Response to Planning application from Hertfordshire County Council (T and CP GDP Order 2015)

District ref: 6/2022/1943/FULL
HCC ref: WH/13629/2022
HCC received: 12 April 2023
Area manager: Matthew Armstrong
Case officer: Senober Khan

LAND BETWEEN 48 & 50 THE RIDGEWAY CUFFLEY EN6 4BA

Erection of a new dwelling with associated landscaping works

Drawing Number **086 PL 17**

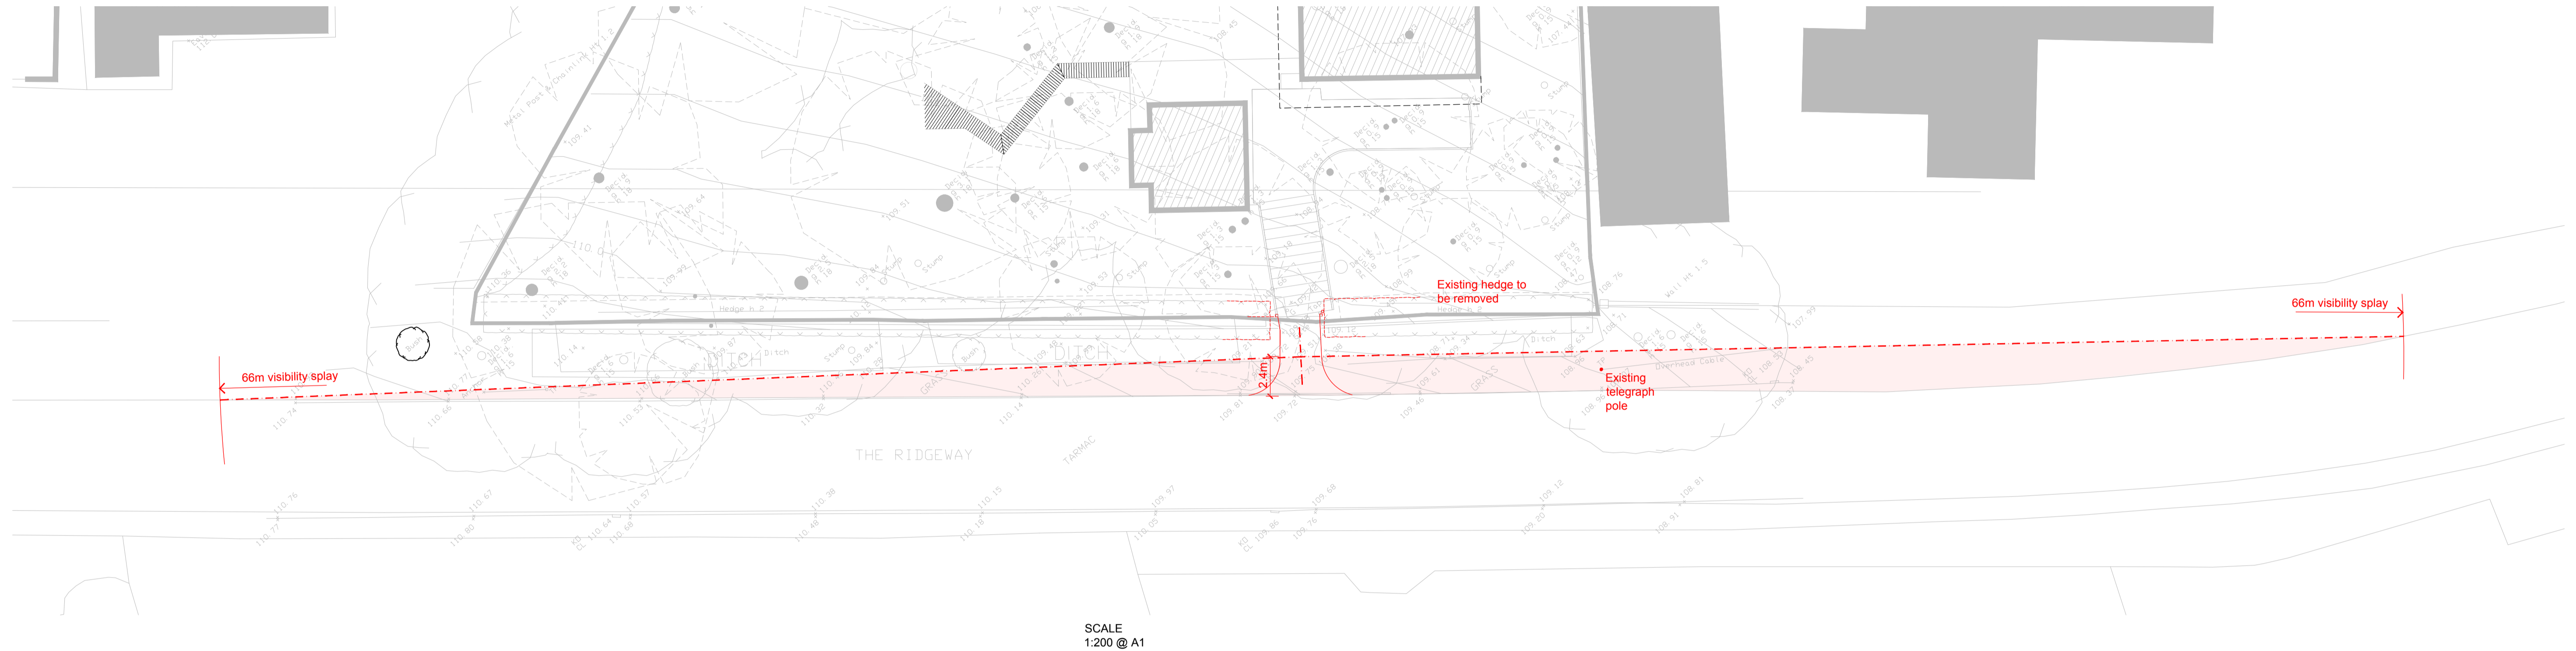
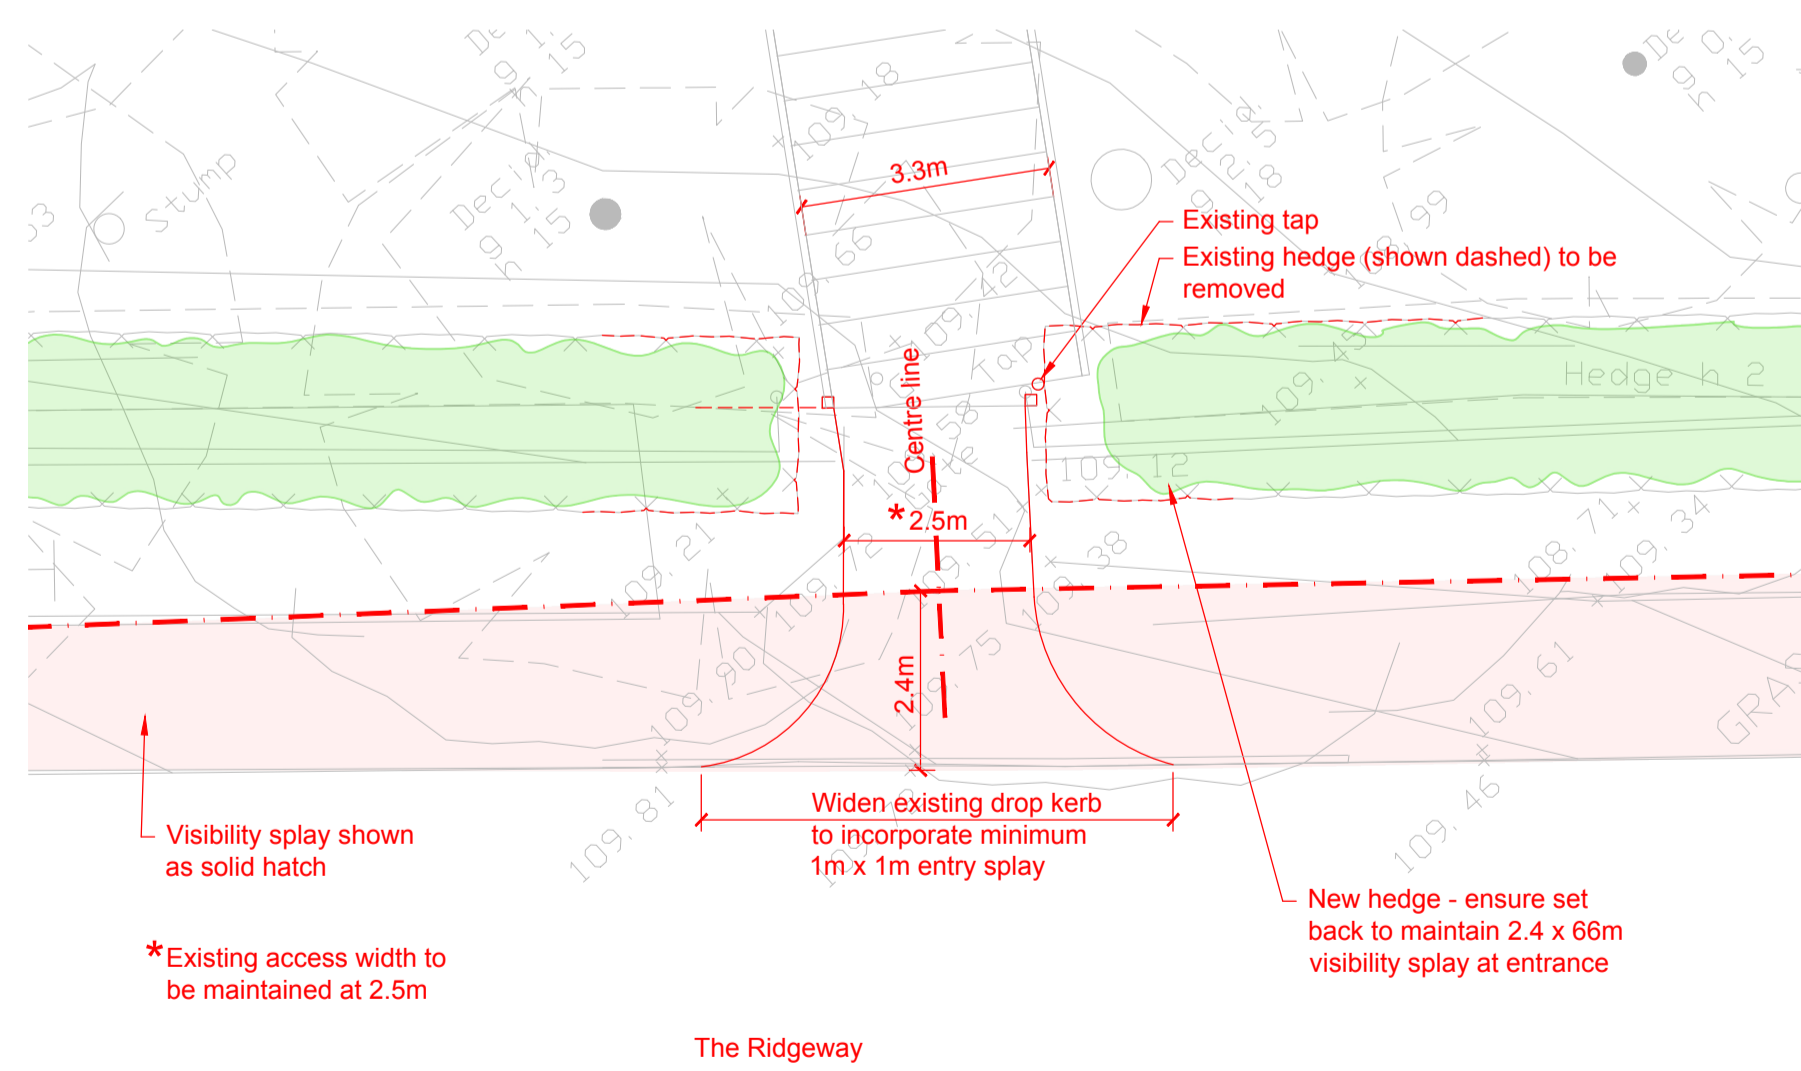
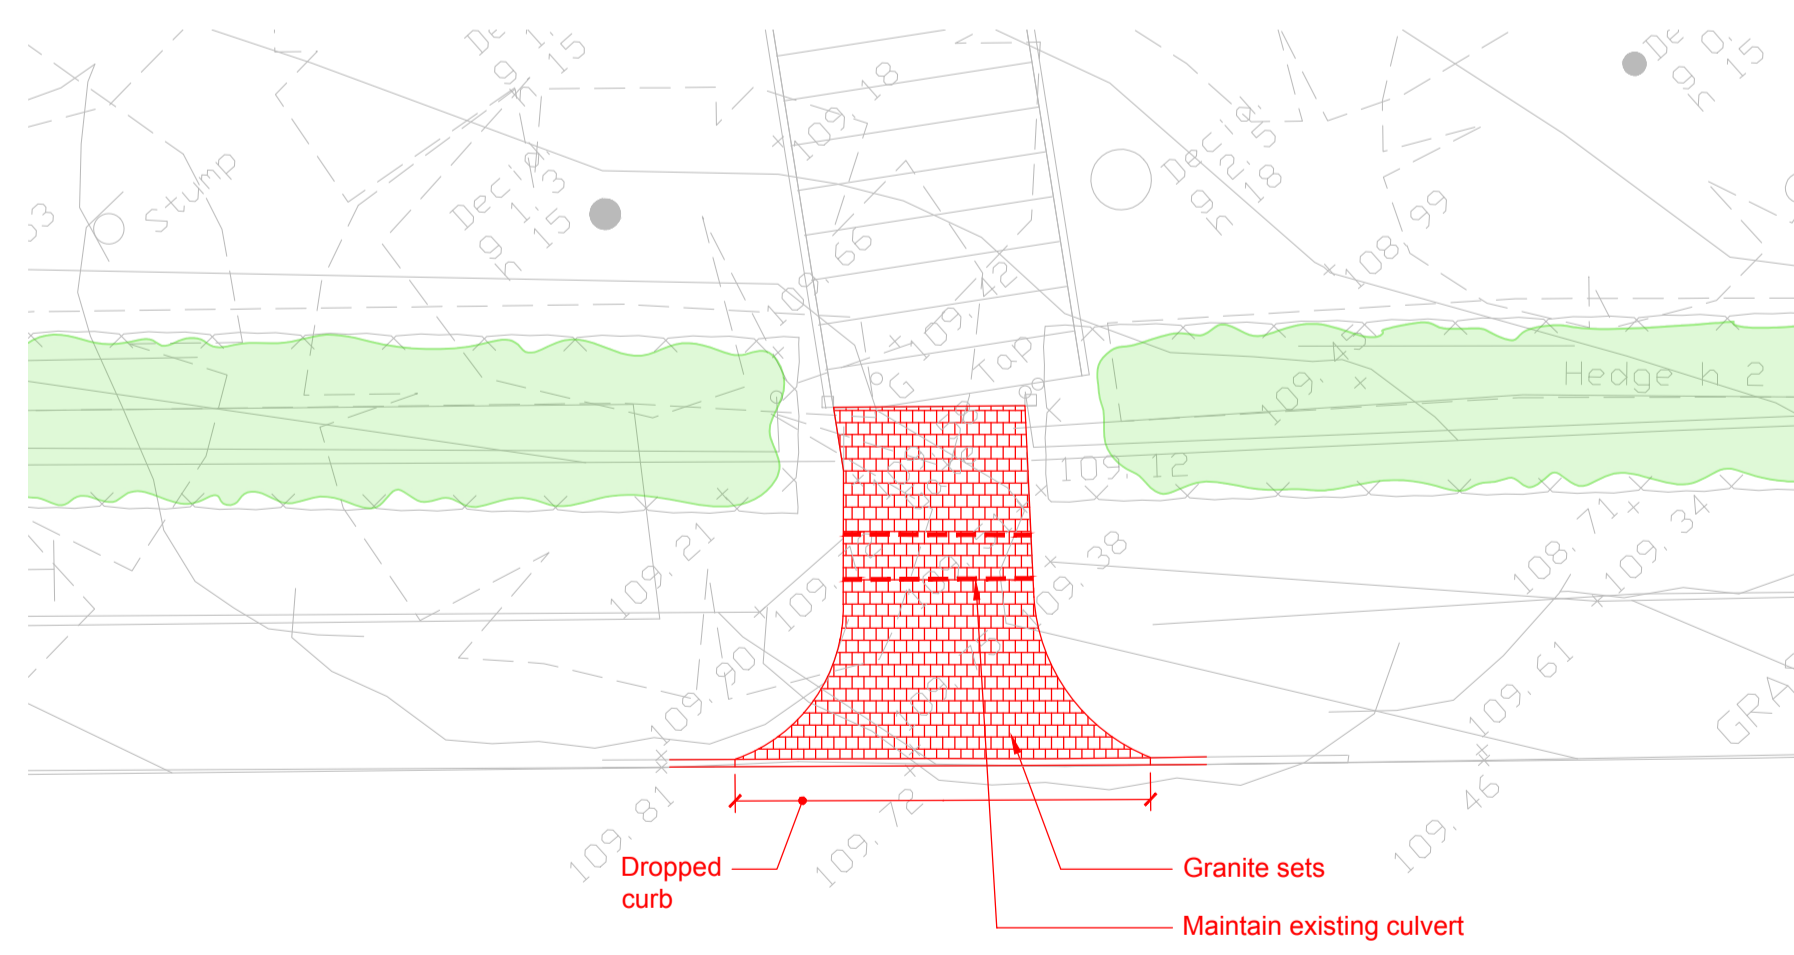
No development shall commence until detailed technical plans are submitted to and approved in writing by the Local Planning Authority, in consultation with the Highway Authority, which show the detailed engineering designs and construction of the vehicle access and associated highway works, as shown indicatively on the aforementioned submitted drawing number 086 PL 17 rev C titled Vehicle access and visibility splay. These works shall be constructed to the specification of the Highway Authority and Local Planning Authority's satisfaction and completed before commencement of work of the development. This shall include the permanent provision of visibility splays measuring 2.4m x 66m, within which there shall be no obstruction to visibility between 600mm and 2 metres above the carriageway level.

Prior to the first occupation/use of the development hereby permitted the vehicular access shall be installed in accordance with the approved detailed technical plans and thereafter retained and maintained at all times at the position shown. Arrangement shall be made for surface water drainage to be intercepted and disposed of separately so that it does not discharge from or onto the highway carriageway.

In response to the HA's comments dated 9th March 2023, the case officer received and forwarded to the HA amended 'vehicle access & visibility splay' plan (Drawing no. 086 PL 17 rev C) without the gate. The agent says the aim is to form the access as a setted crossover, (like a pavement crossover without a pavement), not like a minor road junction, so no upstanding kerbs, but with swept sides to facilitate easy left in/left out movements from the highway.

Subsequently, the HA is satisfied that the gate has been removed.
